**Town of Addison
Summary of Engineering Revision Comments**

Development: Galaxy FBO

Town Project #:19-09D

SHEET NUMBER
C03.02

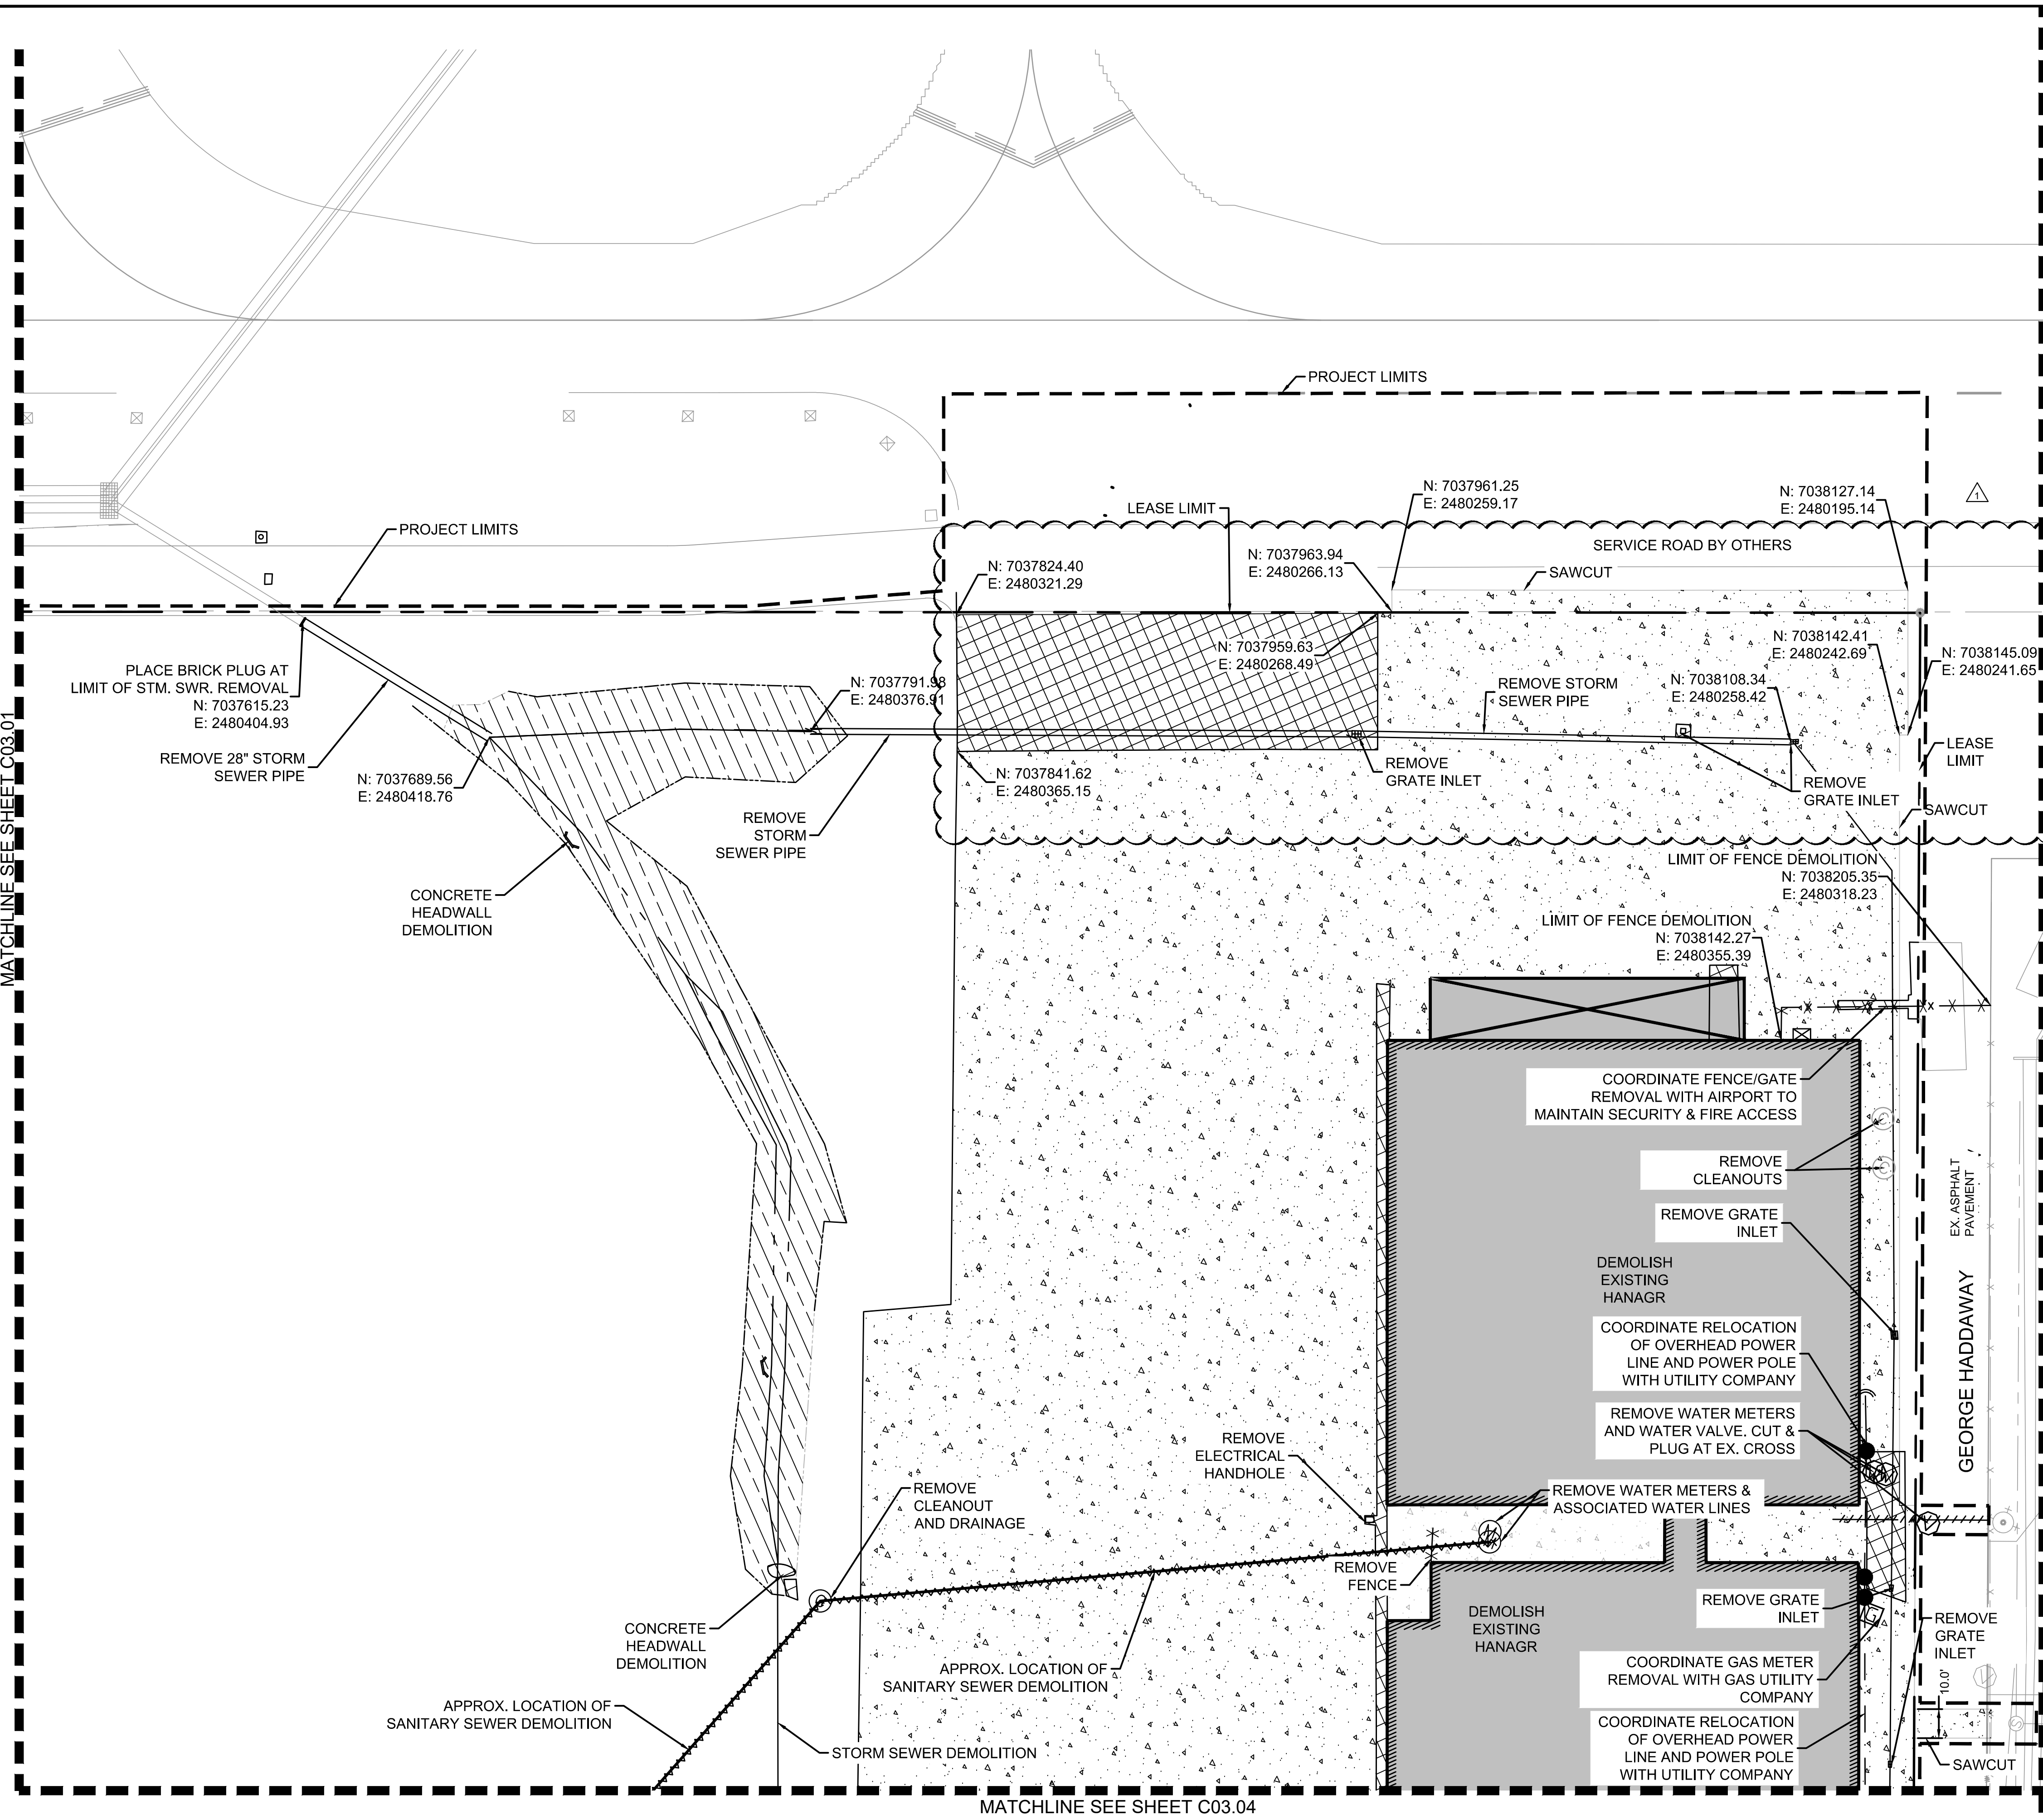
Revision No.	Date	Page No.	Comments	Reason for changes
ASI-C006	10/30/2020	C03.02	Updated the demo limits along the edge of the perimeter road per field conditions verified by a construction progress topographic survey.	
ASI-C006	10/30/2020	C04.01	Updated apron layout/geometry per field conditions verified by a construction progress topographic survey.	
ASI-C006	10/30/2020	C04.02	Updated apron layout/geometry per field conditions verified by a construction progress topographic survey.	
ASI-C006	10/30/2020	C05.01	Updated door locations on Hangar 1 to coordinate with revised architectural plans.	
ASI-C006	10/30/2020	C05.03	Updated door locations on Hangar 3 to coordinate with revised architectural plans.	
ASI-C006	10/30/2020	C06.01	Updated joint layout based on the minor apron layout/geometry changes.	
ASI-C006	10/30/2020	C06.02	Updated joint layout based on the minor apron layout/geometry changes.

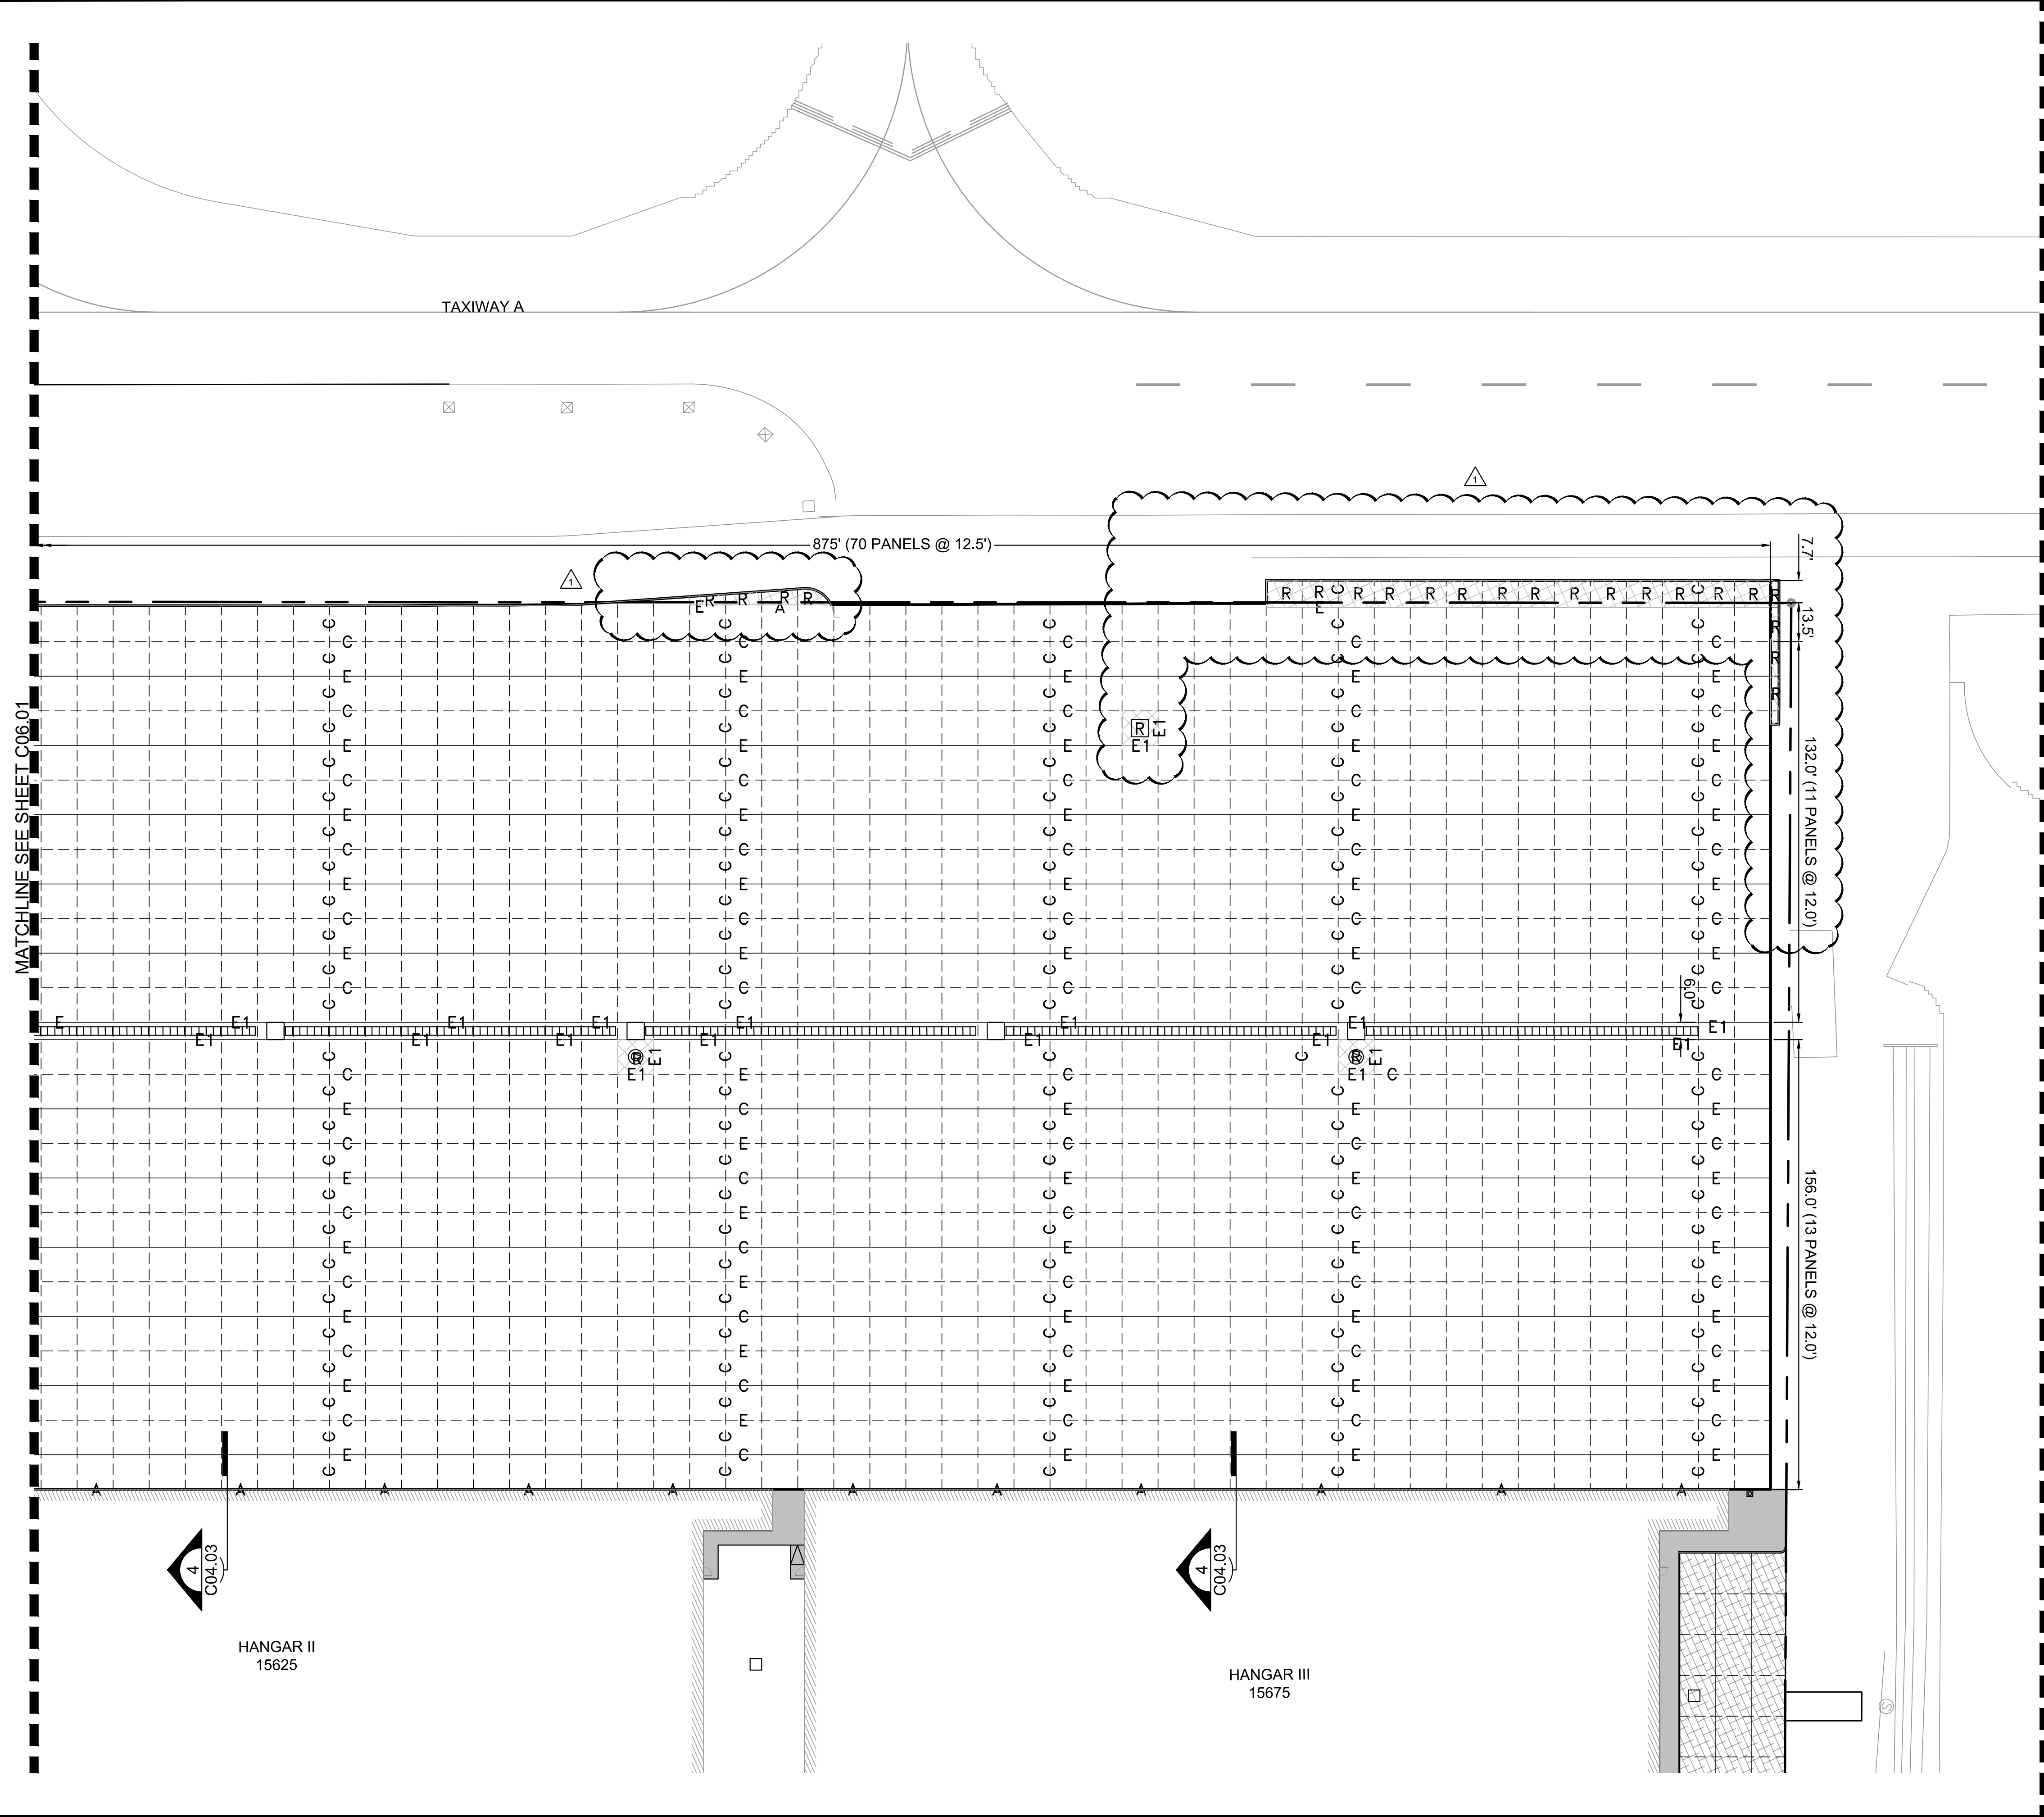
ASI-C006	10/30/2020	C08.01	Updated grading per field conditions verified by a construction progress topographic survey.	
ASI-C006	10/30/2020	C08.02	Updated grading per field conditions verified by a construction progress topographic survey.	
ASI-C006	10/30/2020	C08.03	Updated grading per field conditions verified by a construction progress topographic survey.	
ASI-C006	10/30/2020	C09.01	Updated grading per field conditions verified by a construction progress topographic survey.	
ASI-C006	10/30/2020	C09.02	Updated grading per field conditions verified by a construction progress topographic survey.	
ASI-C006	10/30/2020	C09.03	Updated grading per field conditions verified by a construction progress topographic survey.	
ASI-C006	10/30/2020	C10.02	Updated grading per field conditions verified by a construction progress topographic survey.	
ASI-C006	10/30/2020	C10.03	Updated grading per field conditions verified by a construction progress topographic survey.
